Application Reference: 2025/0789

Site Address: 5 Woodbourne Gardens, Tankersley, Barnsley, S75 3DX

Introduction: Remove existing conservatory and extension and erect a two-storey rear extension with Juliet balcony to dwelling. (Amended Projection)

DRAWING TITLE
EXISTING AND PROPOSED BLOCK PLAN

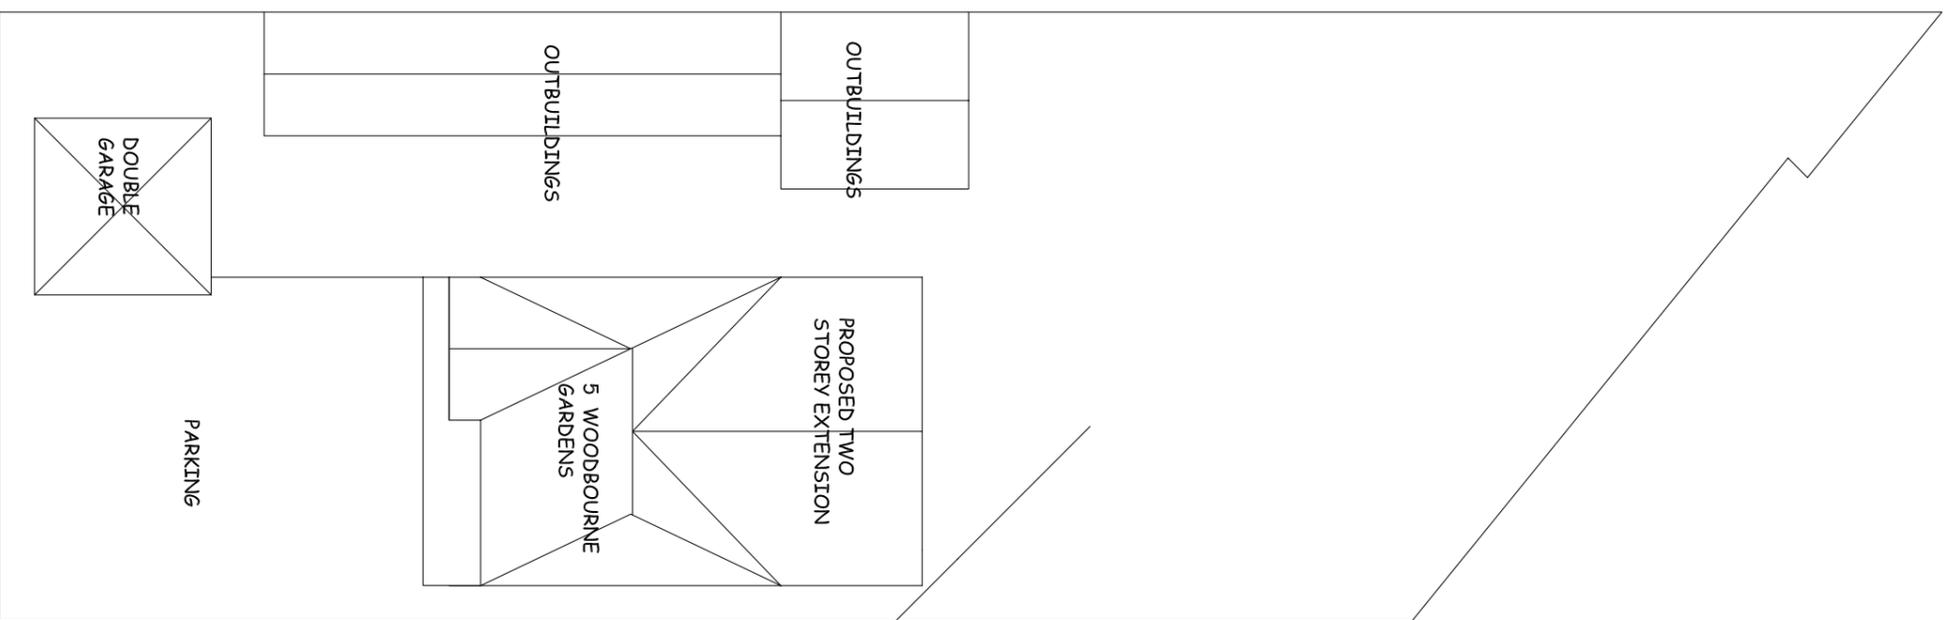
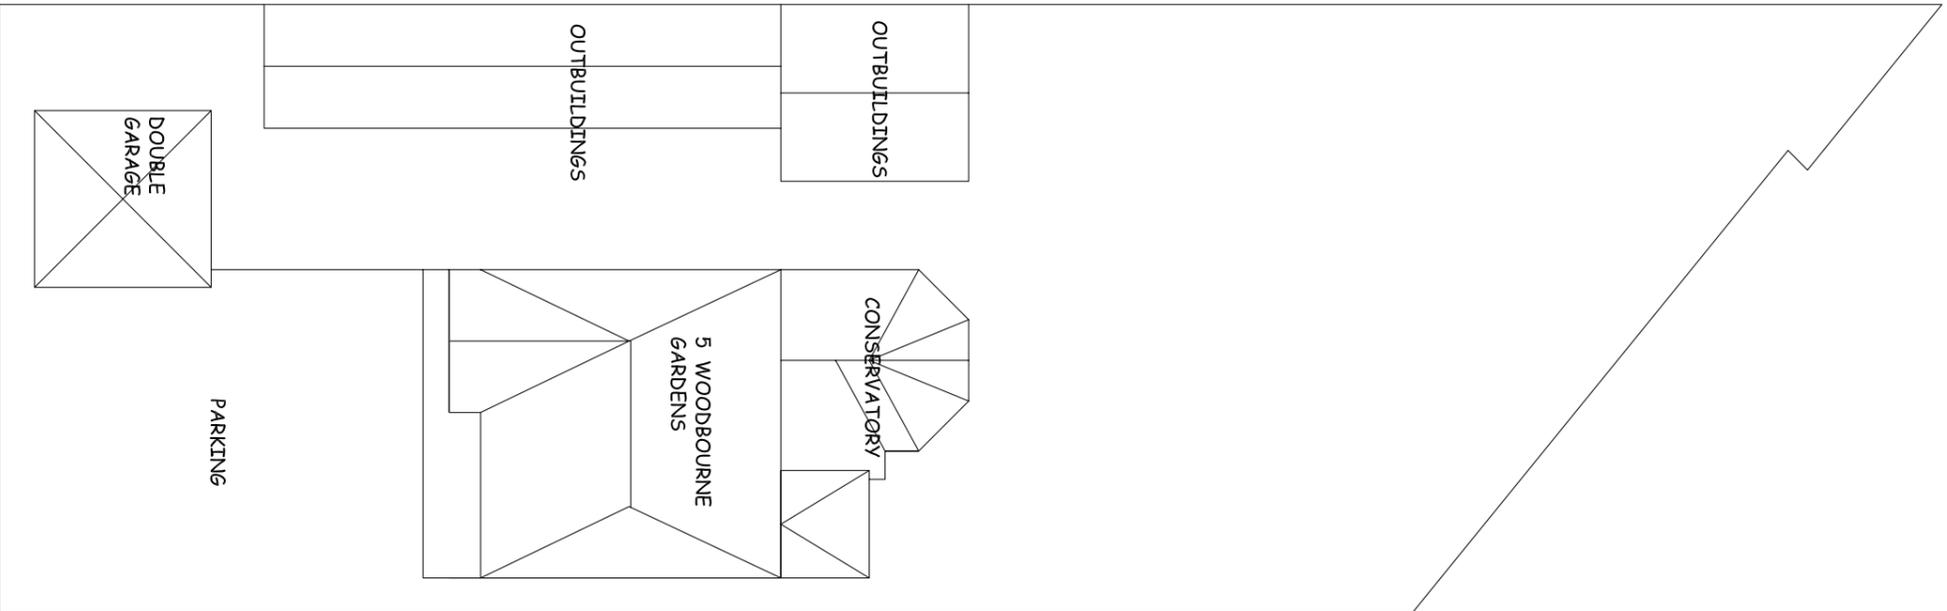
The proposed extension would have some impact on the neighbouring property to the northeast. The original 5 metre projection of the extension has been reduced to 4 metres which lessens the impact of the proposal, especially in the early hours of the day, when the proposal is likely to be most impactful. The amendment also prevents the extension from impacting upon the 45 degree angle of the nearest neighbouring window, allowing for acceptable levels of neighbouring outlook. The topography of the site and the neighbouring dwelling to the northeast is acknowledged, however the extensions reduction to 4 metres and the use of existing substantial boundary treatment results in proposal which would provide some levels of overshadowing and dominance, however not to a level which would be considered detrimental.

It has been necessary to make contact with the applicant to make amendments to the rear projection of the proposal. The proposed rear projection was reduced from 5 metres to 4 metres. Further amendments were required to correct the labelling of the bedroom and bathroom and to include the French doors on the southwest elevation. All amendments were received.

DRAWING TITLE
 PROPOSED PLANS AND ELEVATIONS

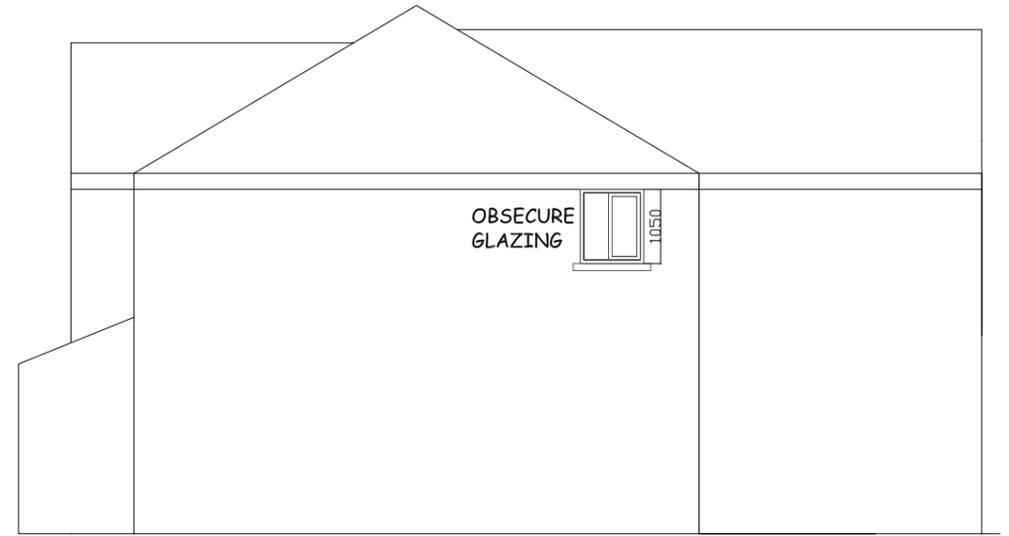
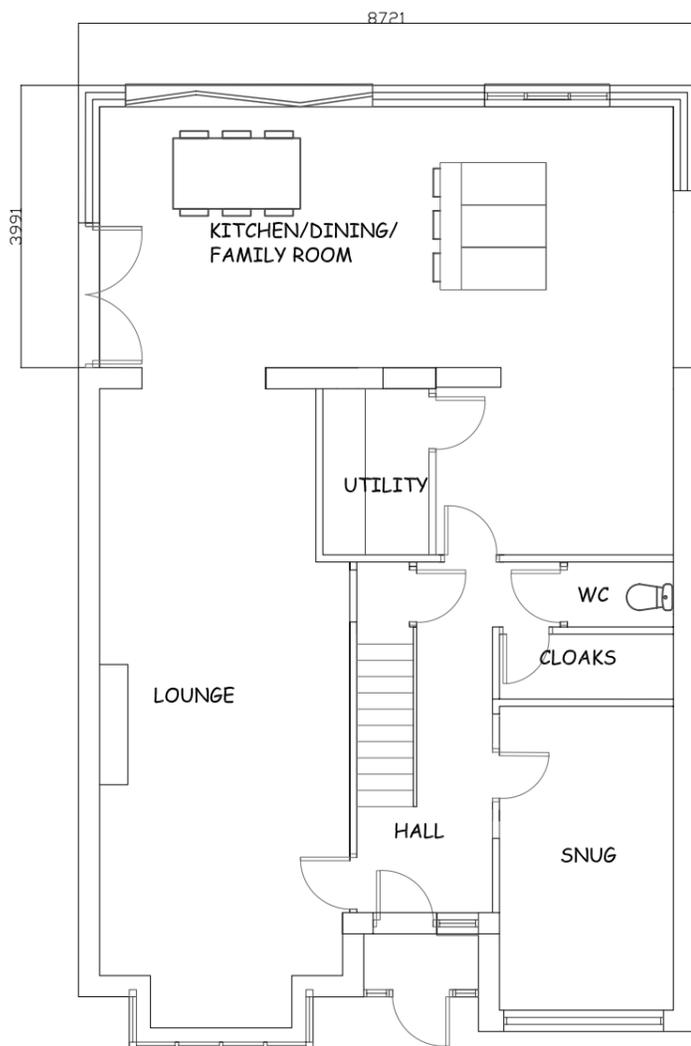
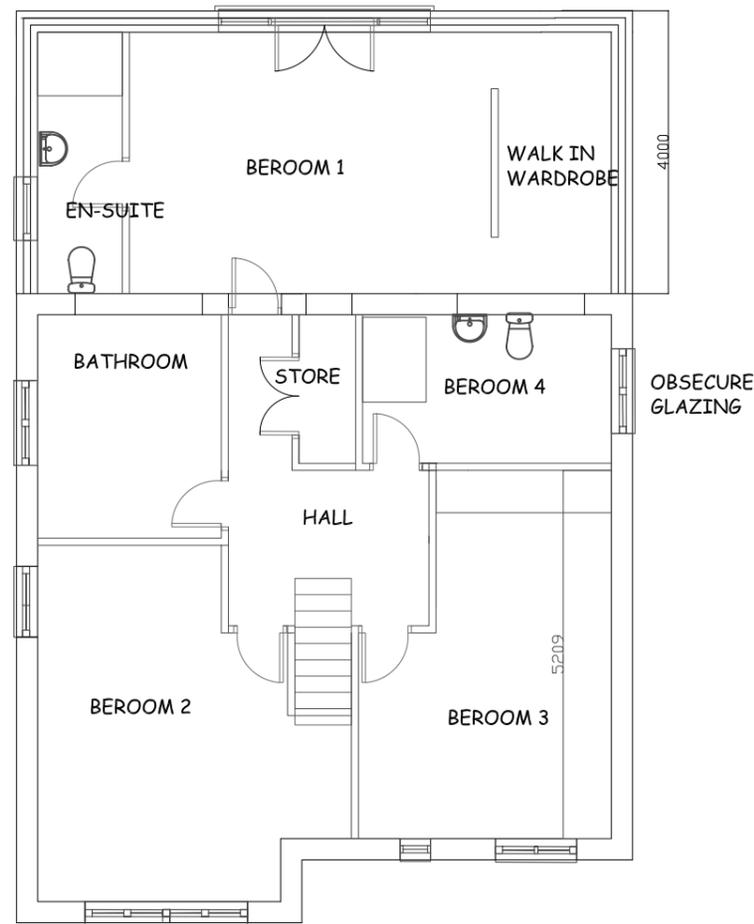
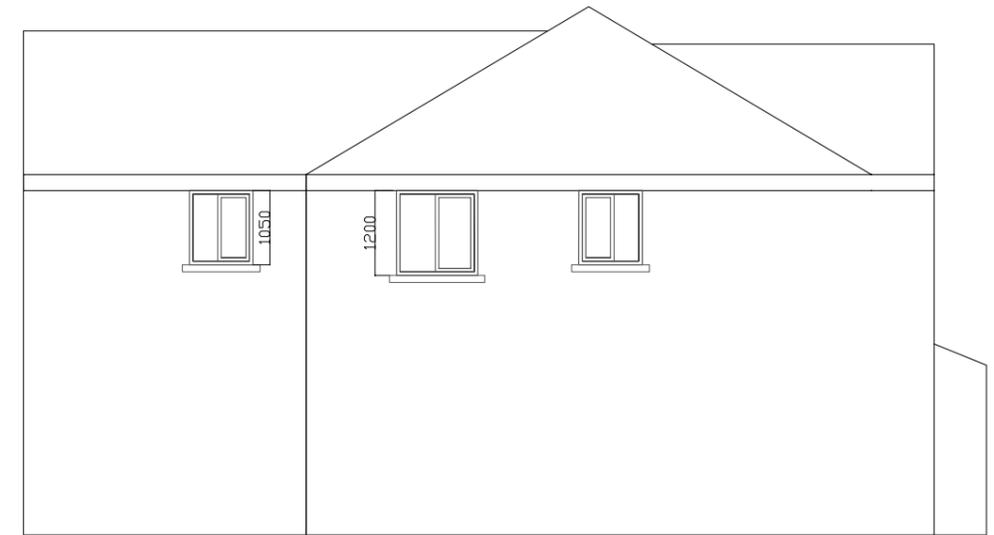
Glazing to the northeast elevation of the extension, servicing a bathroom has been detailed to be obscured glazing and will also be conditioned to be obscured glazing in order to protect the privacy of the both the applicant and neighbours. Although not facing any neighbours, the proposed glazing to the southeast elevation servicing an en-suite shall also be conditioned to be obscured glazing in order to protect the privacy of the applicant and members of the public.
